Item No. **Report of the Head of Planning, Sport and Green Spaces**

Address 58 BRIDLE ROAD EASTCOTE

Development: Part two storey, part single storey front/side/rear extension involving demolition of existing side/rear elements

LBH Ref Nos: **18519/APP/2015/3980**

Drawing
Proposed First Floor Plan

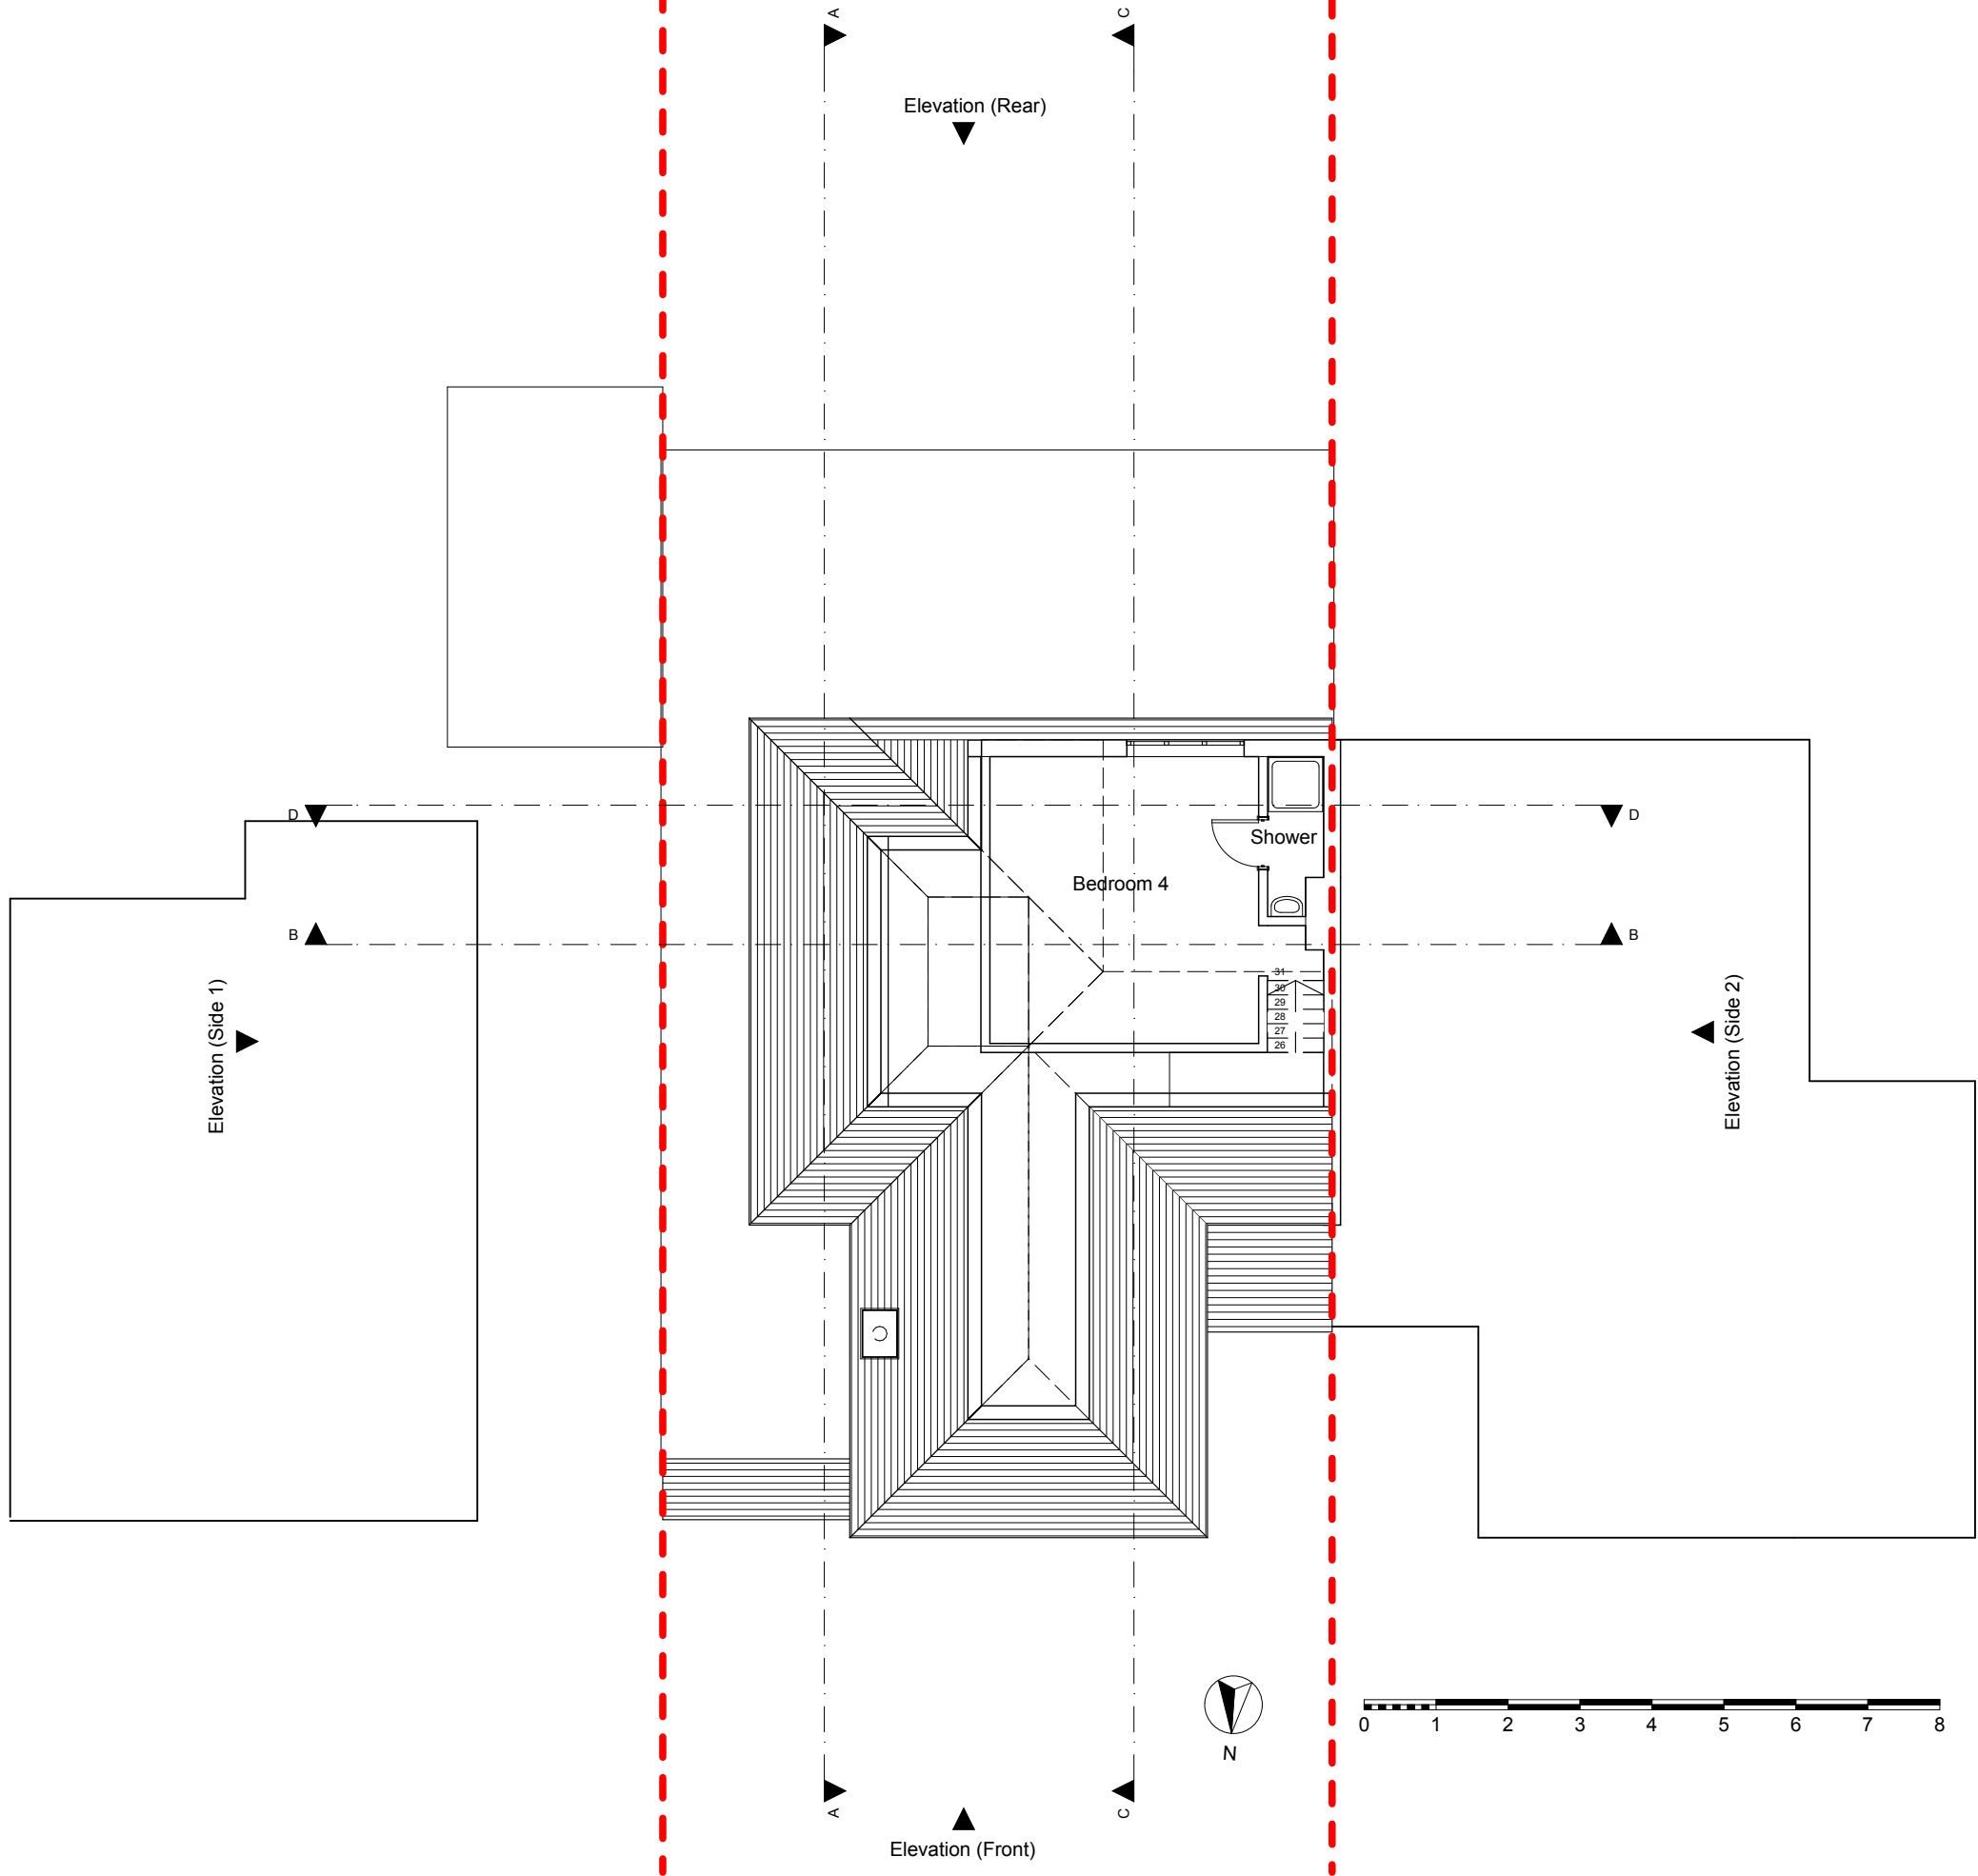
The first floor of the proposed two storey side extension would be set back 3.5m from the projecting front wall of the dwelling, be 1.4m wide and set in 1.5m from the eastern side boundary with No.60. The first floor would be 6.45m deep and have a hipped roof set down from the main roof of the dwelling by 0.9m. Paragraph 5.1 of the Council's adopted HDAS SPD: Residential Extensions (December 2008) requires all extensions and buildings of two or more storeys to be set back a minimum of 1m from the side boundary of the property for the full height of the building. This is to ensure the protection of the character and appearance of the streetscene and the gaps between properties - preventing houses from combining visually to form a terraced appearance. Paragraphs 5.6 and 5.8 specify that for two storey side extensions at semi-detached dwellings, both the ground and first floors should be set-back from the front building line of the house to ensure a subordinate appearance, and that the roof height of the extension should be lowered by at least 0.5m at roof level. Paragraph 5.10 specifies that the width of a side extension should be between half and two thirds of the main house depending on the plot size and character of the area. The set down of the roof of the first floor of the two storey side extension from the existing main roof would comply with paragraph 5.8 of the HDAS SPD. The 1.4m and 2.9m widths of the first and ground floors of the side extension are

less than half of the width of the existing dwelling (6.5m). The 1.5m set in of the first floor of the side extension from the eastern side boundary exceeds the required minimum of 1m. However, the lack of a set-in of the ground floor of the side extension from the side boundary and the absence of a set back of the ground floor from the front wall of the dwelling are such that the overall bulk of the two storey side extension would not result in a subordinate appearance to the dwelling. The unextended dwelling to the east at No.60 has not been extended to the side, thereby maintaining a considerable visual gap (particularly at upper level) between and around the adjacent end of No.60. It is considered that the inadequate set in of the ground floor of the proposed side extension from the boundary with No.60 is such that it would close up the visual gap, and result in a terracing effect in the event of a side extension being erected at that neighbouring dwelling. The proposed two storey side extension would therefore fail to respect the spacing character of the development context in the area. The inadequate set in from the side boundary and lack of a set back from the front wall would result in the two storey side extension constituting an ungainly and disproportionate addition to the existing dwelling. It is therefore considered that the proposed two storey side extension would significantly detract from the architectural integrity of the existing dwelling and the character and appearance of the area. It would therefore conflict with the requirements of Policy BE1 of the Hillingdon Local Plan: Part One - Strategic Policies (November 2012) and Policies BE13, BE15 and BE19 of the Hillingdon Local Plan: Part Two - Saved UDP Policies (November 2012) and the guidance contained in the HDAS SPD: Residential Extensions (December 2008).

Proposed Side 1 and Front
Elevations

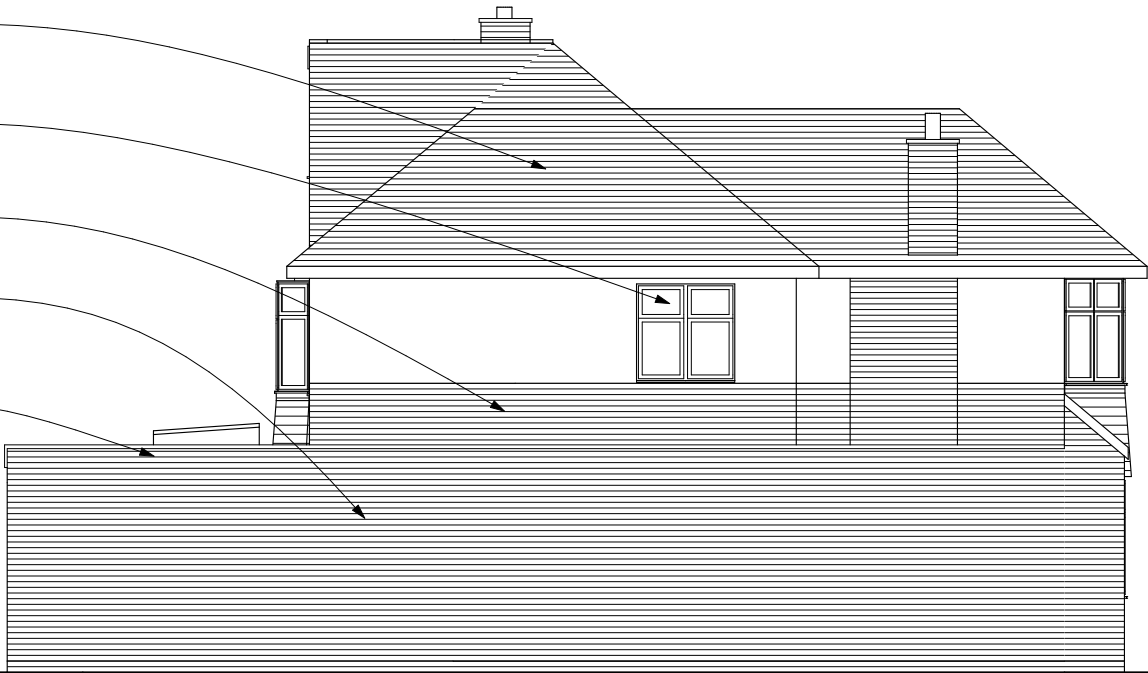
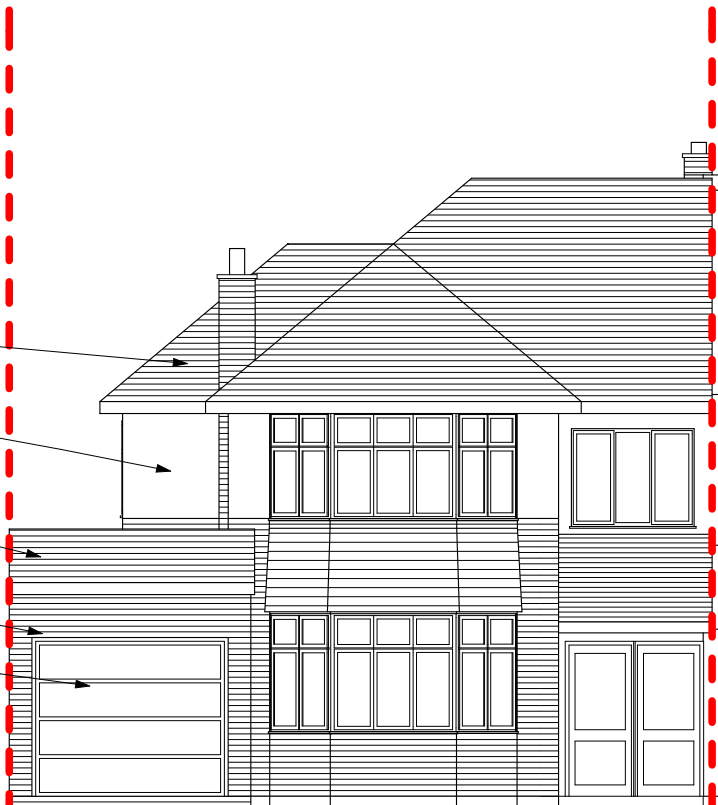
The proposed two storey side extension, by reason of its siting, size, scale and design, including the lack of a set back from the front at all levels, would fail to appear as a subordinate addition and would thus be detrimental to the appearance of the original dwellinghouse, the visual amenities of the streetscene and the character and appearance of the surrounding area. The proposal is therefore contrary to Policy BE1 of the Hillingdon Local Plan: Part One - Strategic Policies (November 2012), Policies BE13, BE15 and BE19 of the Hillingdon Local Plan: Part Two - Saved UDP Policies (November 2012) and the adopted Supplementary Planning Document (SPD) HDAS: Residential Extensions (December 2008).
